Application No: WA/93/20/PL
Site Address: Land East of Tye Lane Walberton BN18 0LU
Description of works: Alternative vehicular access off Tye Lane & emergency access off Avisford Park Road, along with minor highway works following WA/95/18/RES. This site is in CIL Zone 2 (Zero Rated) as other development.

Thank you for your internet representation made on 6th May 2021 which has been recorded as an objection with the comments as follows:

AVISFORD PARK ROAD

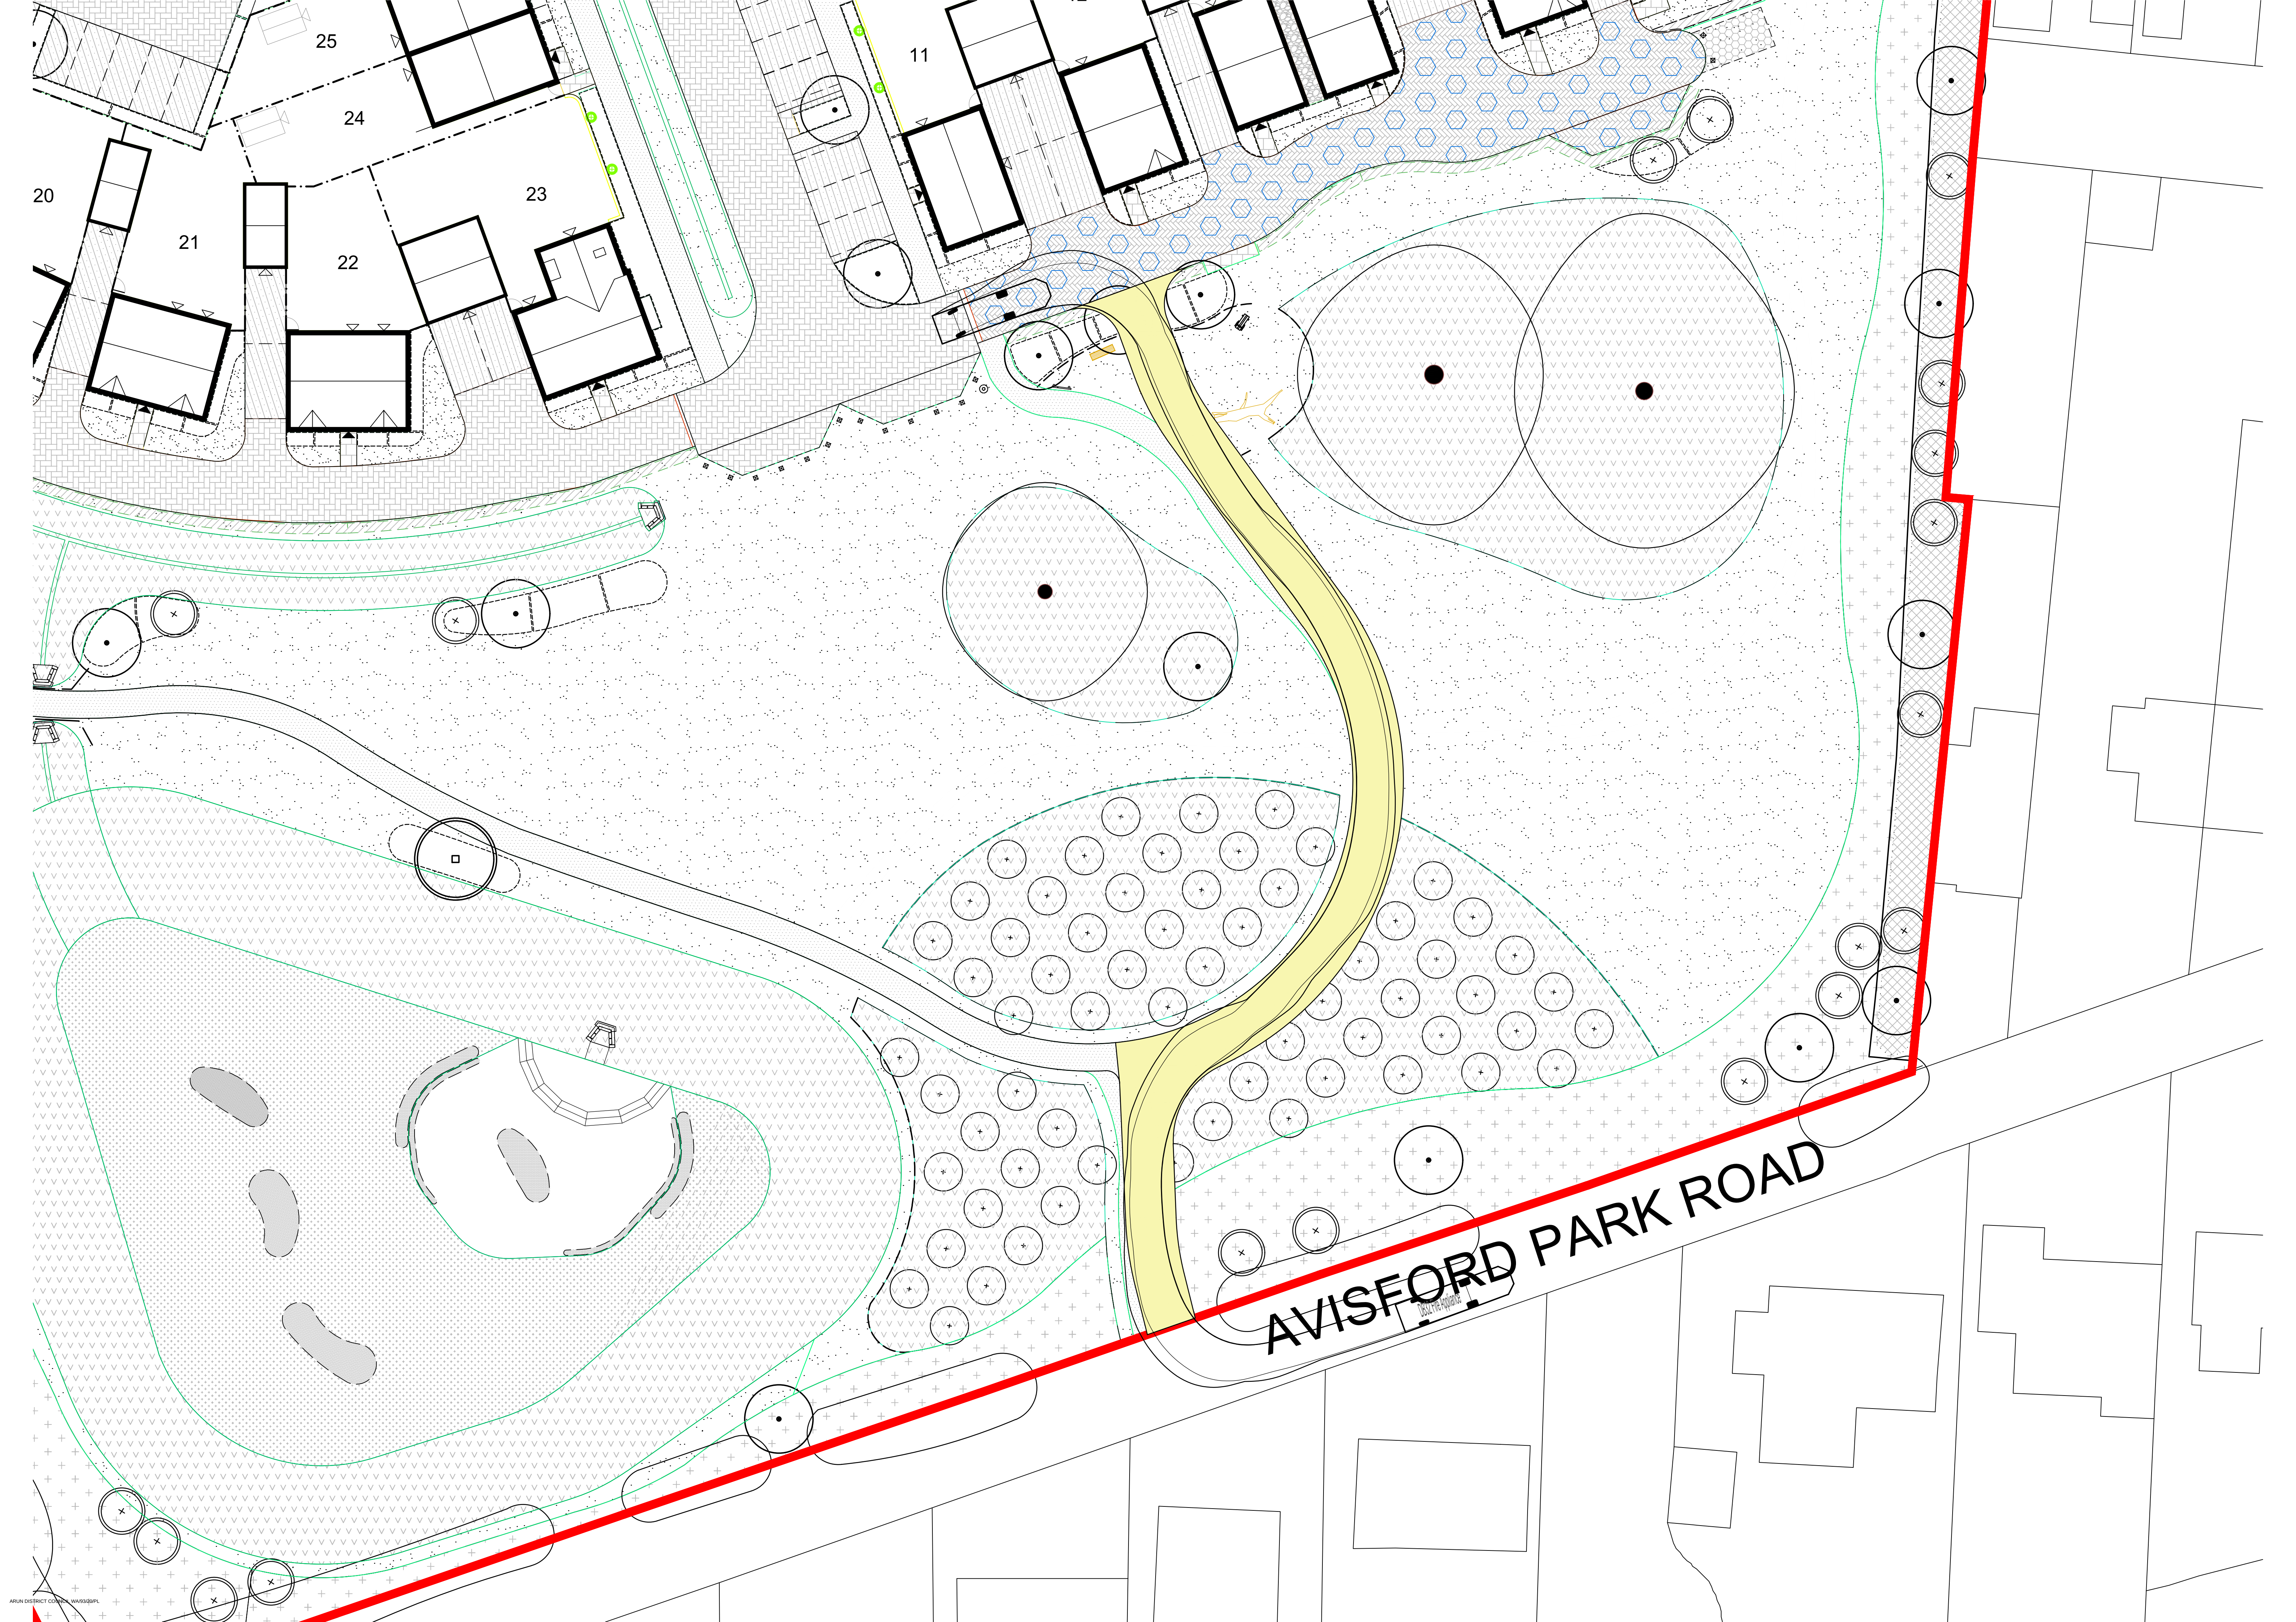
My immediate concern, however, is the access gate in Avisford Park Road.

The Tupper's Field Title plan (WSX267804) shows no legal right of vehicular access from Tupper's field into Avisford Park road and vice versa.

Avisford Park Road is far from ideal for emergency access. It is an unadopted road designated as a footpath and in poor condition with numerous potholes. It is also a narrow cul-de-sac frequently blocked by parked cars

Safety to pedestrians in the parkland or community orchard is also a concern if a new emergency access road is built.

Putting the Emergency access gate Avisford Park Road looks a lot like a Trojan Horse for eventually developing the parkland guaranteed by the developer in exchange for obtaining the original planning permission.
